# Appeal Decision

## Appeal Ref: APP/R5510/D/23/3322306

### 28 Jacks Lane, Harefield, Hillingdon UB9 6HE

- The appeal is made under section 78 of the Town and Country Planning Act 1990 against a refusal to grant planning permission.
- The appeal is made by Mr Ian Belcher against the decision of the Council of the London Borough of Hillingdon.
- The application Ref 76265/APP/2022/1716, dated 20 May 2022, was refused by notice dated 23 February 2023.
- The development proposed is the demolition of a garage and the erection of a part single, part three storey side extension, with alterations to the fenestration.

Side Elevation
As Proposed 1:100

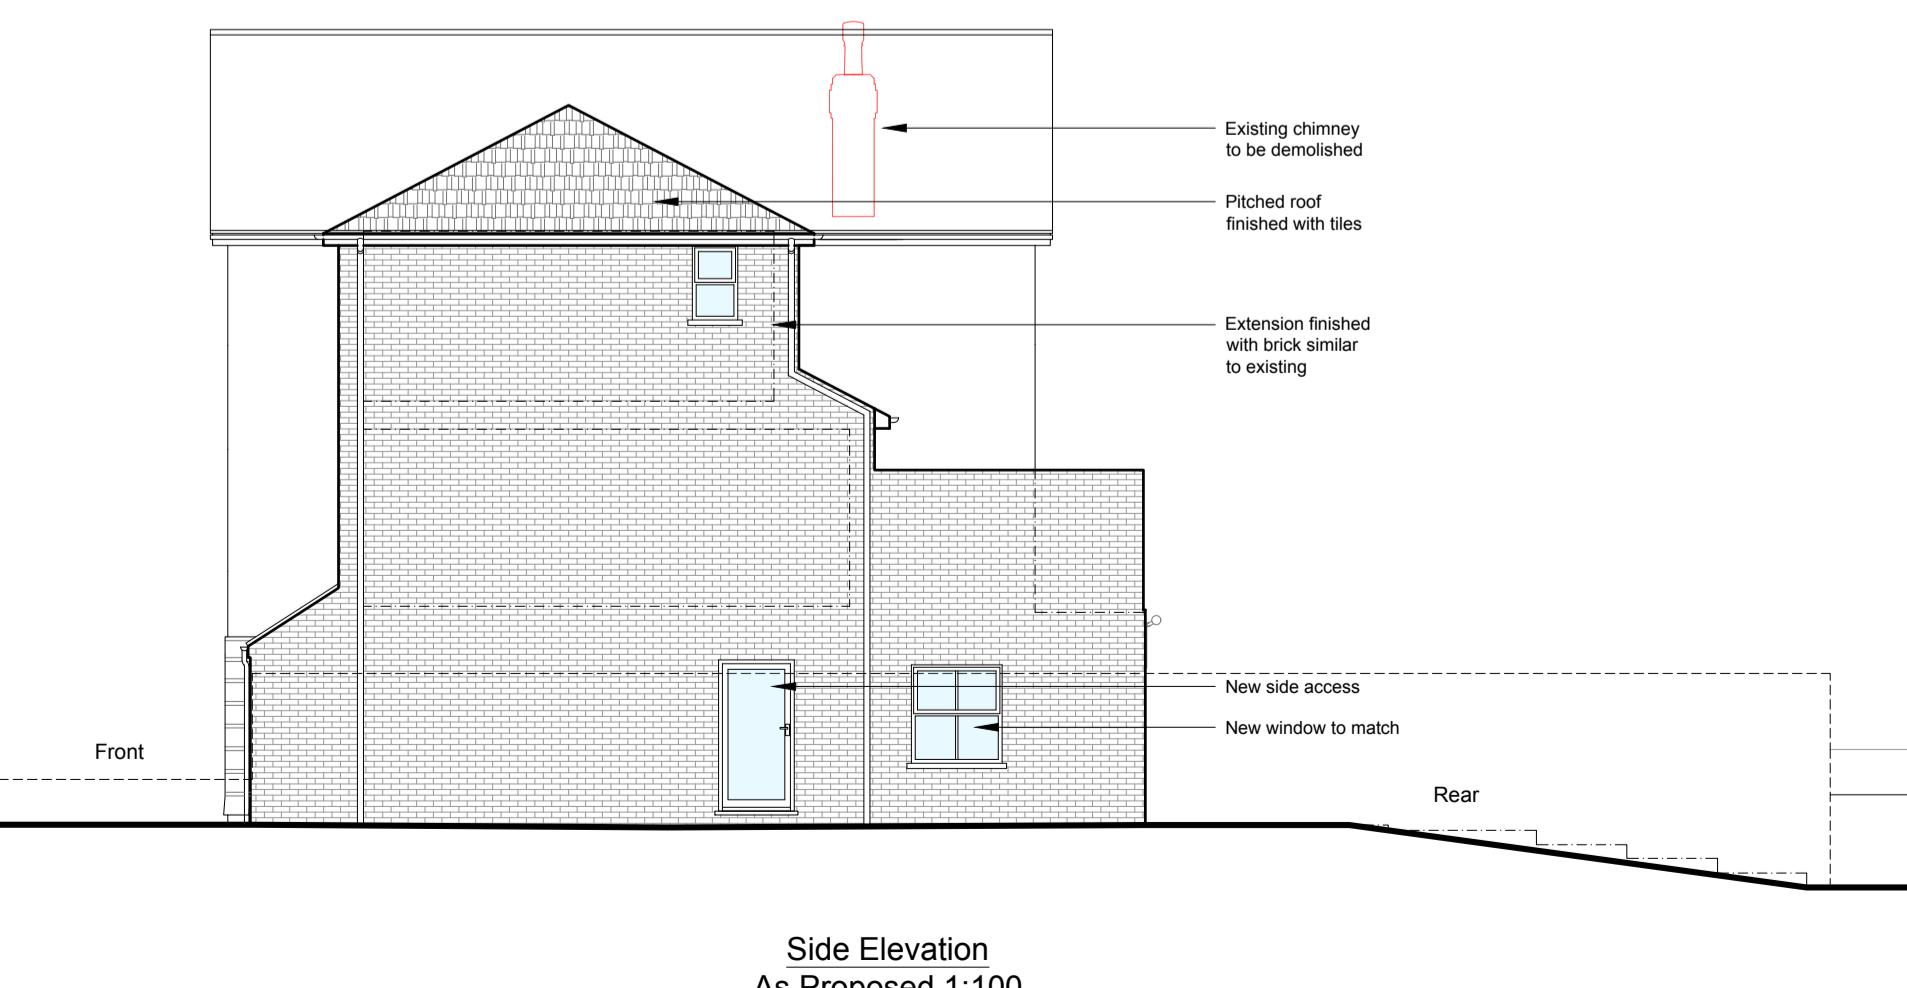
5. However, as a result of this scheme, the flank wall of No 28 would be significantly closer to that window. Given its three storey height and its proximity to the window, which is the only one serving that room, it would be a bulky and looming presence, which would create a significant sense of enclosure within the bedroom, and which would harmfully affect those occupiers' outlook.

7. My finding regarding the impact on No 27's bedroom window would, to a lesser degree, hold true of the impact on the outlook from its office window, which is also the only window serving that room, although I observed on my visit that the aspect from there is already partially constrained by a shed/outbuilding in that property's garden.

Rear Elevation
As Proposed 1:100

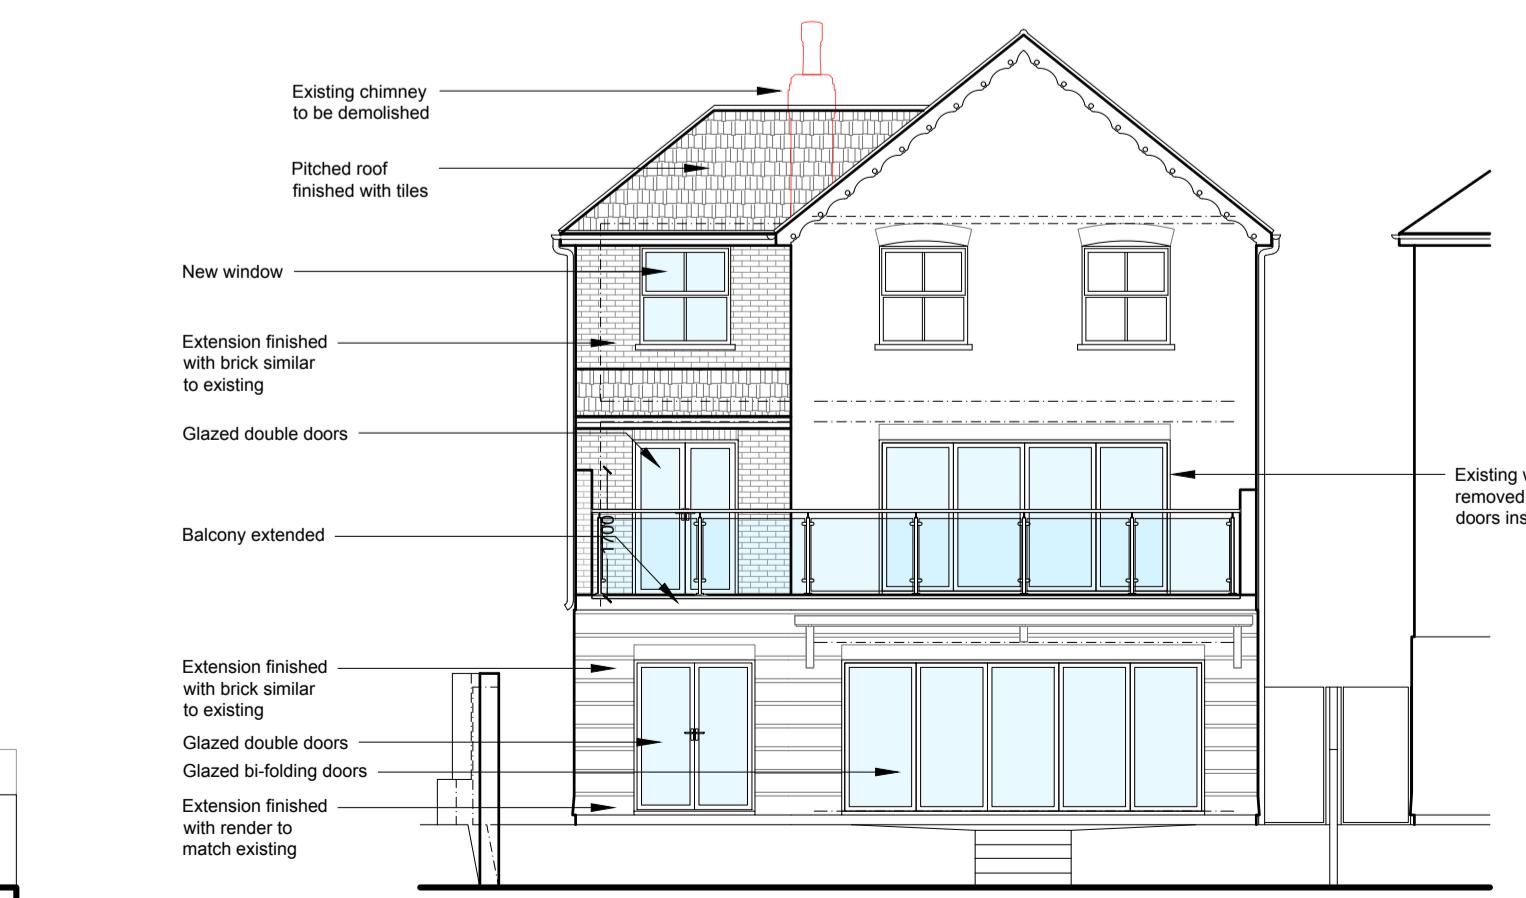
8. The proposed privacy screen would prevent any significant overlooking from the scheme's first floor rear balcony towards No 27, but given the height and bulk of the proposed extension and its proximity to the boundary, I share the neighbours' concerns that it would have a somewhat overbearing impact on those parts of their outdoor amenity space closest to the side boundary.
